IN THE MATTER OF AN APPLICATION FOR DEVELOPMENT CONSENT IN  
RESPECT OF STONESTREET GREEN SOLAR FARM PINS REF EN010135

COUNSEL'S NOTE

1. I provide this note for the Aldington and Bonnington Parish Council in connection with the commencement of the Examination of the Stonestreet Solar Development Consent Order Application (“Application”). I deal briefly with the stage that we have reached in the procedure, and then provide my initial comments on the draft Development Consent Order itself (“dDCO”).
2. I note at the outset that I have been instructed by another party to advise in relation to the Application which has given me some background information about the Application. I do not consider that there is any conflict of interest in advising the Parish Council on this limited set of instructions.

2.3(B) Works Plans

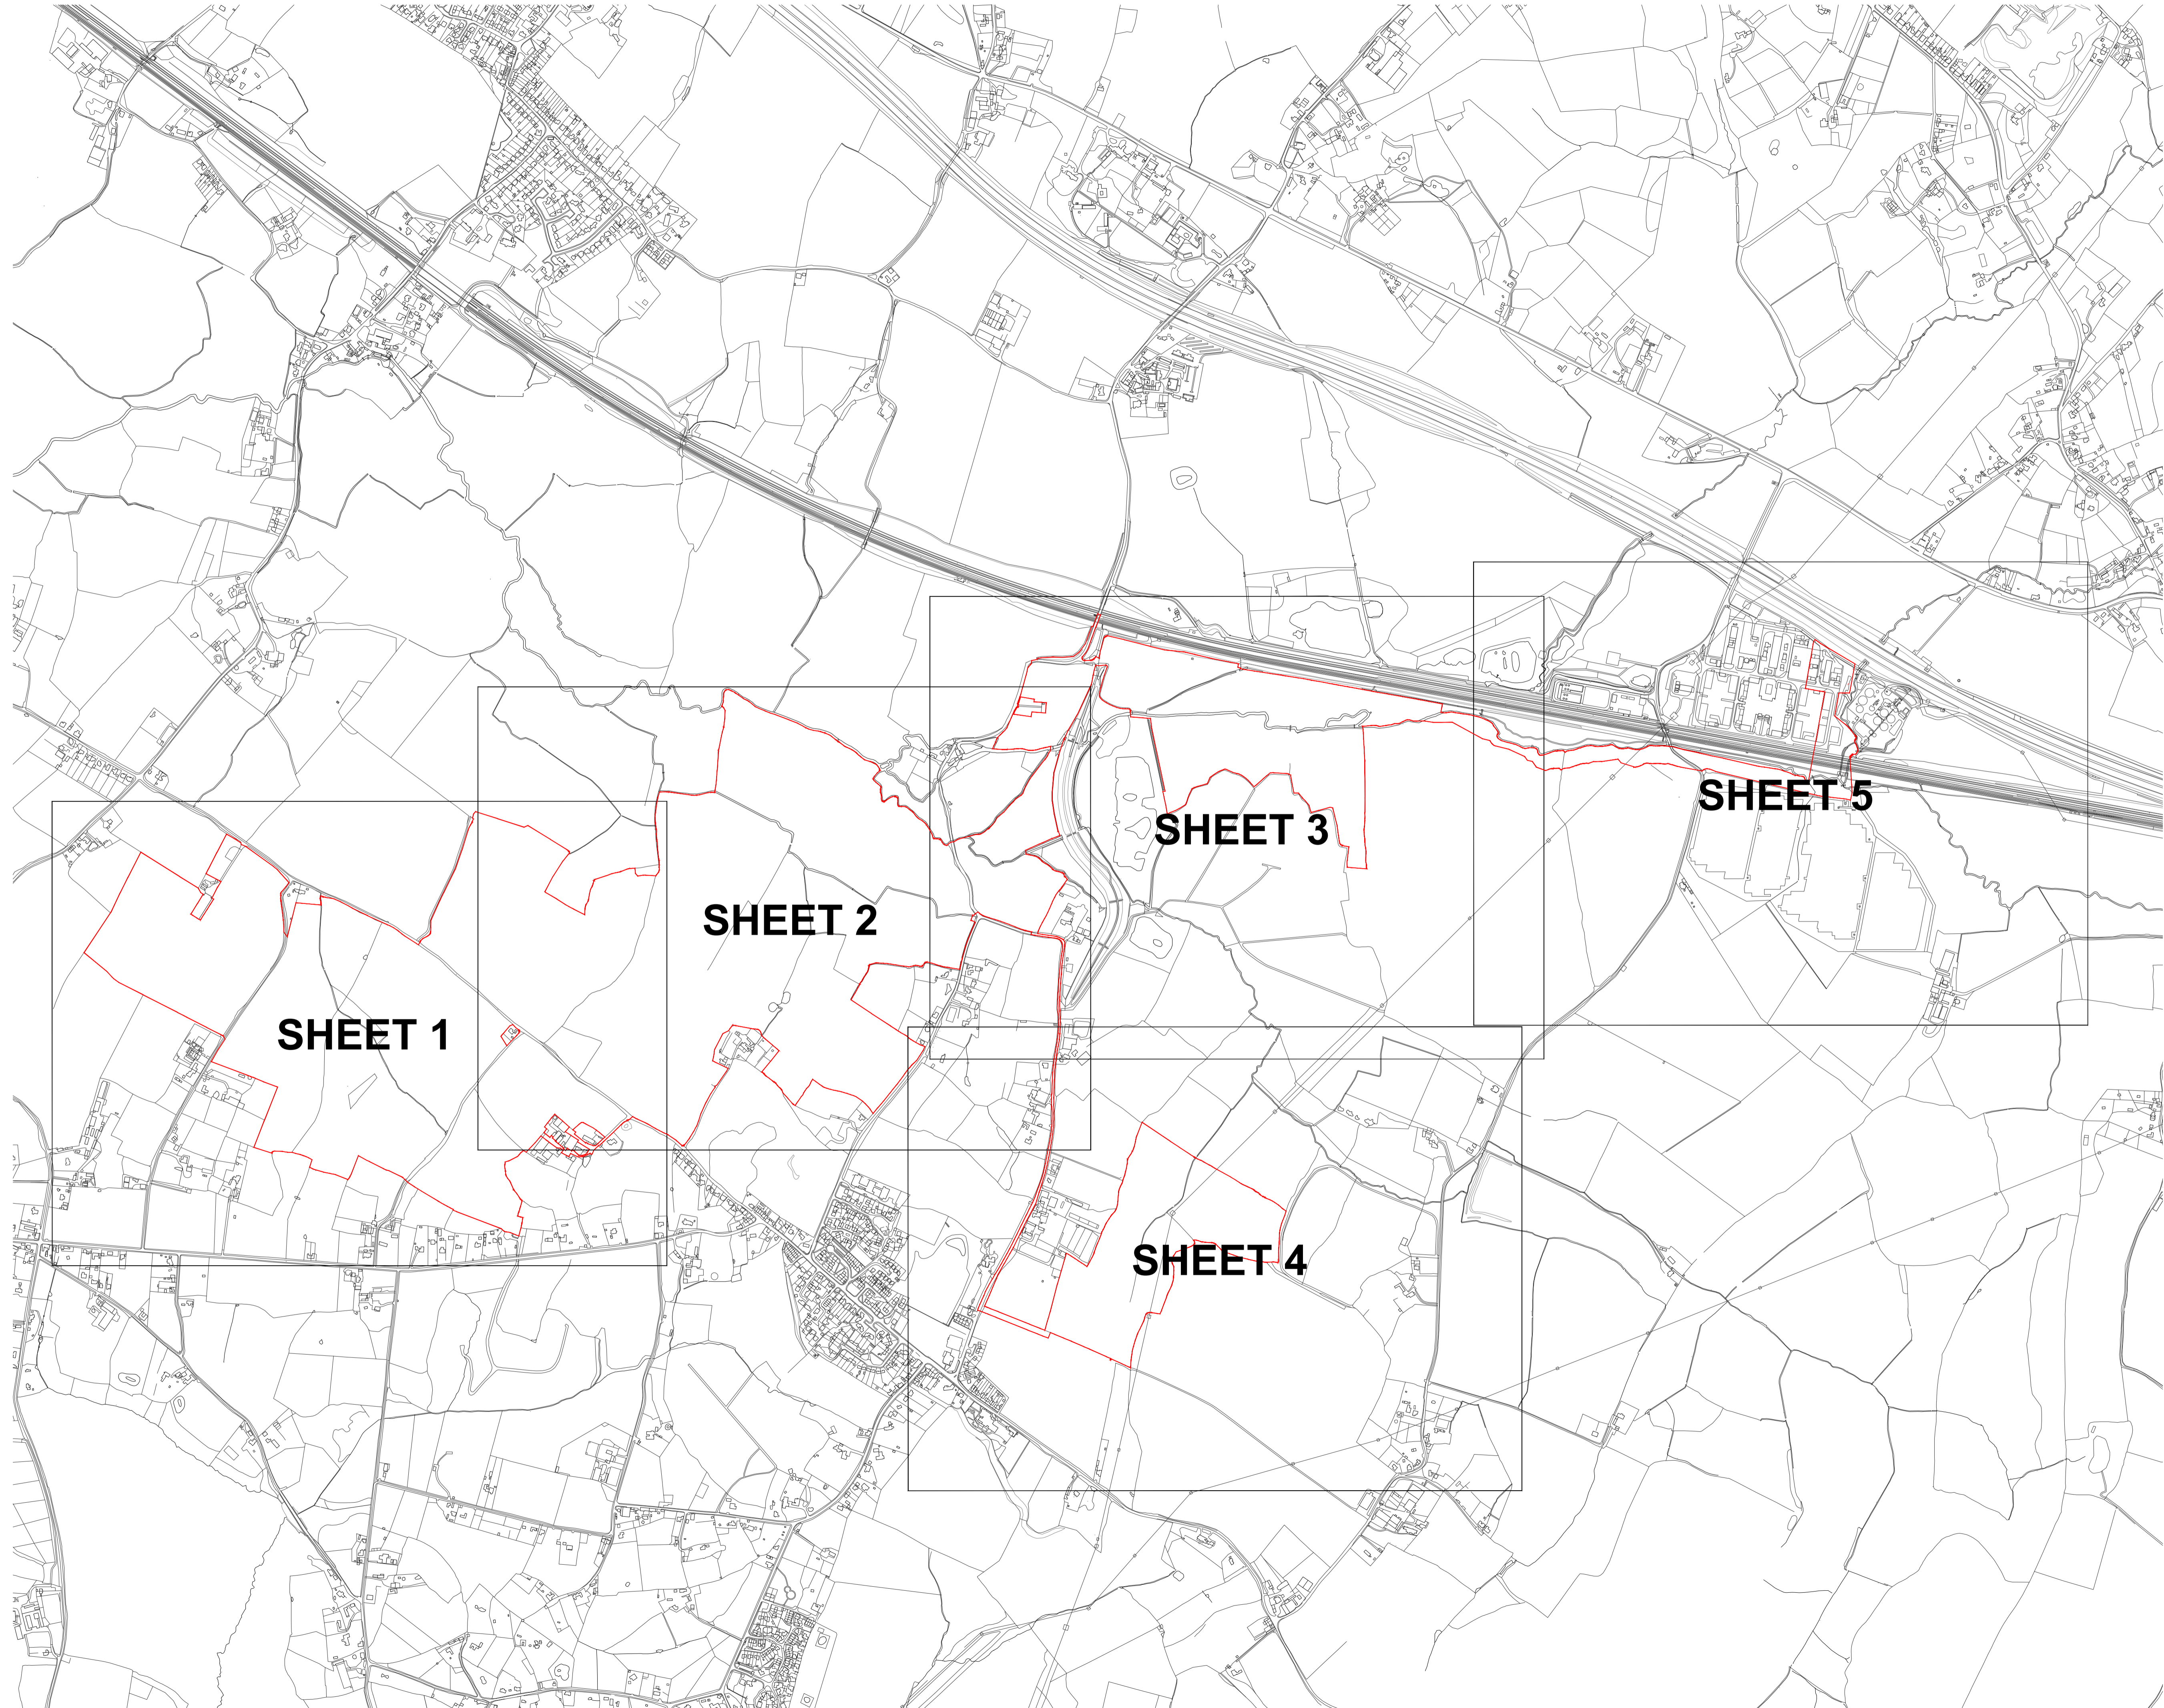
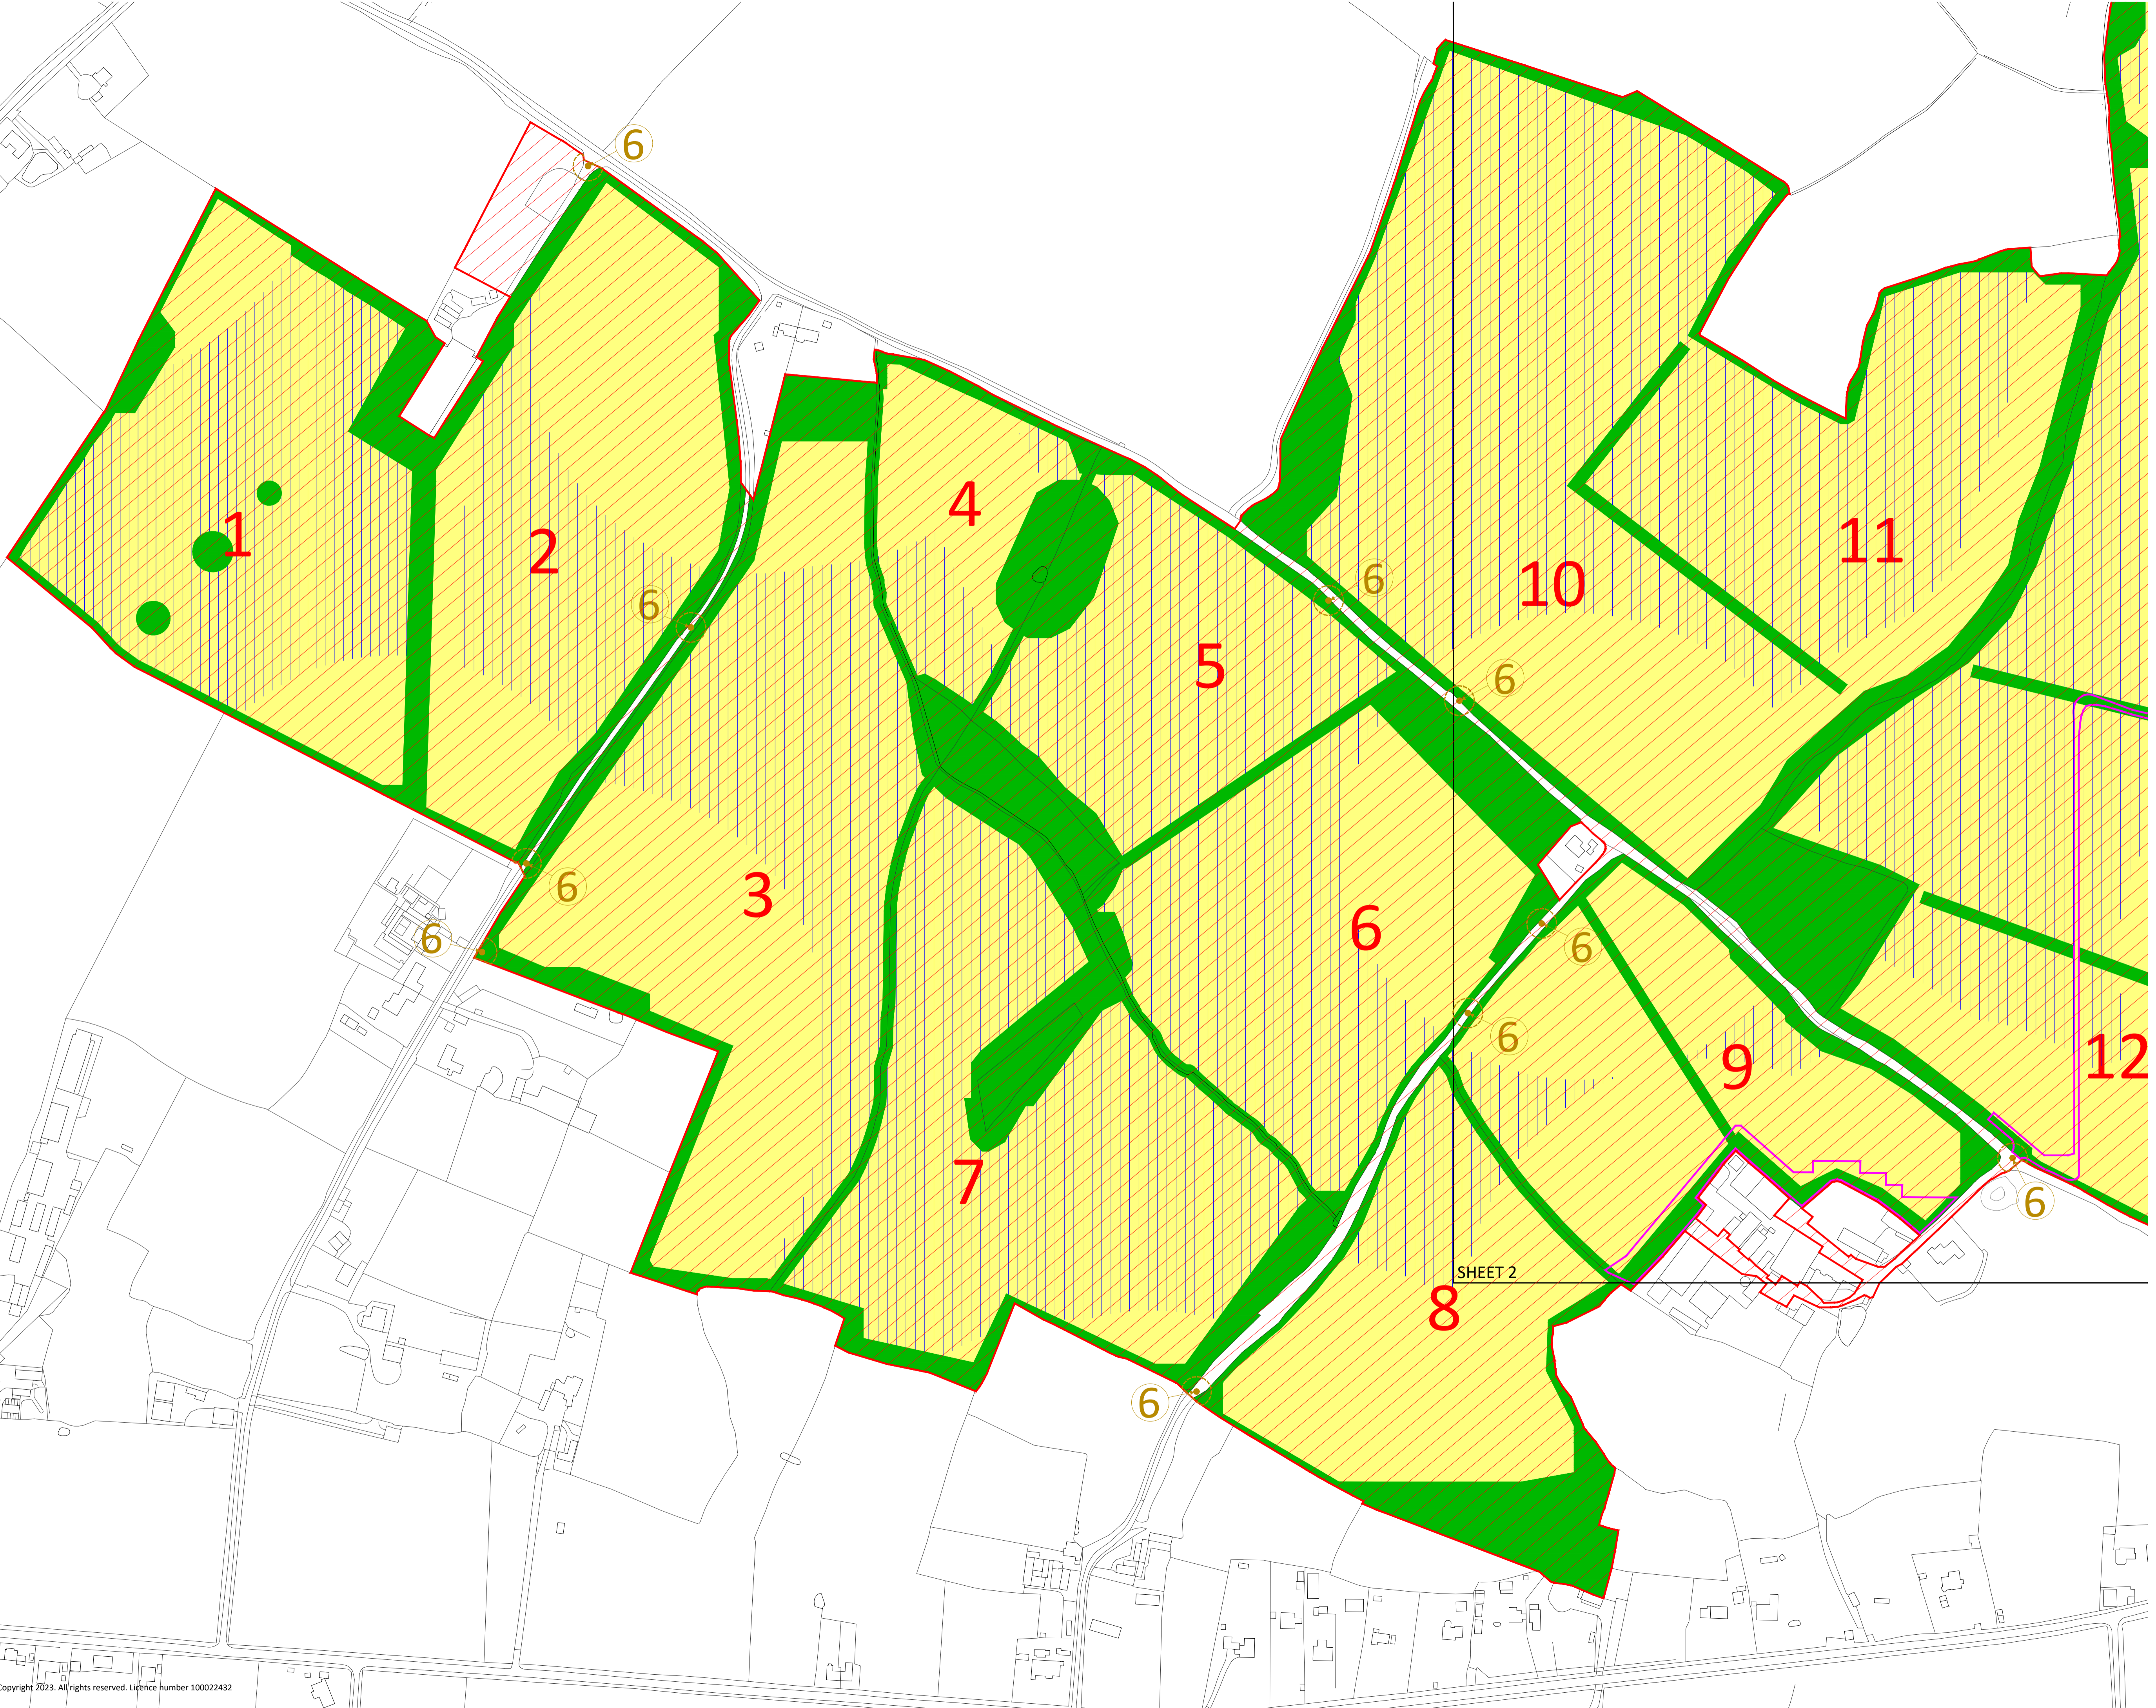
11. This is important, as the Work Plans which accompany the dDCO are incredibly generic about the location of key elements of the scheme, merely providing an indicative hatching across most of the site for both the solar array (Work 1) and the battery component of the scheme (included within Work 2).

14. Secondly, given that there is no number of or approximate locations for the battery storage and connected elements of the scheme, I find it difficult to understand how the Rochdale envelope can be robustly created – is the Applicant going to assume as a

worst-case scenario that *all* the land hatched on the Work Plans for Work 2 will be occupied by batteries and their infrastructure? That would on one level be absurd, but on another, if there is an unlimited number of batteries permitted across that whole area, then that is what the Rochdale envelope requires to be assessed.
